From:
Sent: 16 January 2025 00:06
To: DC Admin
Subject: Planning Application 2024/93055, Land Adj 2 Hopton Hall Lane, Upper Hopton, Mirfield, WF14 8EP

With reference to your letter of 13th December 2024 informing us of the above planning application we would like to make the following comments:

EAST ELEVATION  
1:100

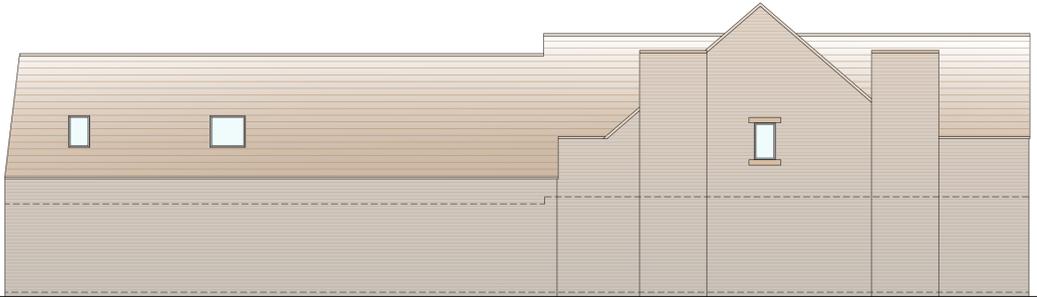
2. There are 4 ground floor windows which face nos 1 and 3 Fairways. (These were (conveniently?) omitted from the original elevation drawing.) With these windows being so close to the boundary, we feel these would result in an invasion of privacy to these 2 properties.

GROUND FLOOR PLAN  
1:100

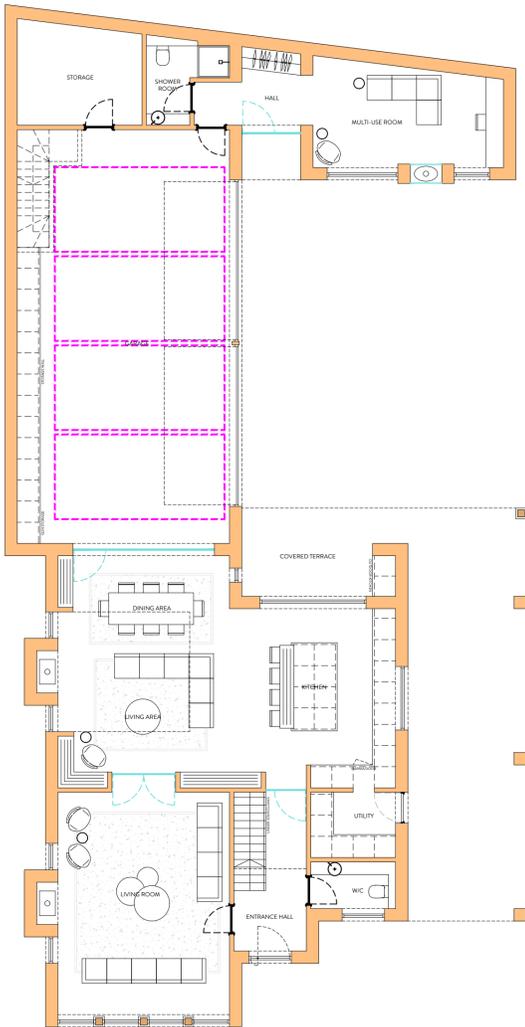
1. This is an extremely large overbearing development which is approximately 1m from our boundary at the closest point. Given that 2 Hopton Hall has a large area in which to develop, it seems unreasonable to build so close to our property. There is certainly scope to build the property further away. The proximity could also create issues with access to maintain the boundary wall at the closest points.
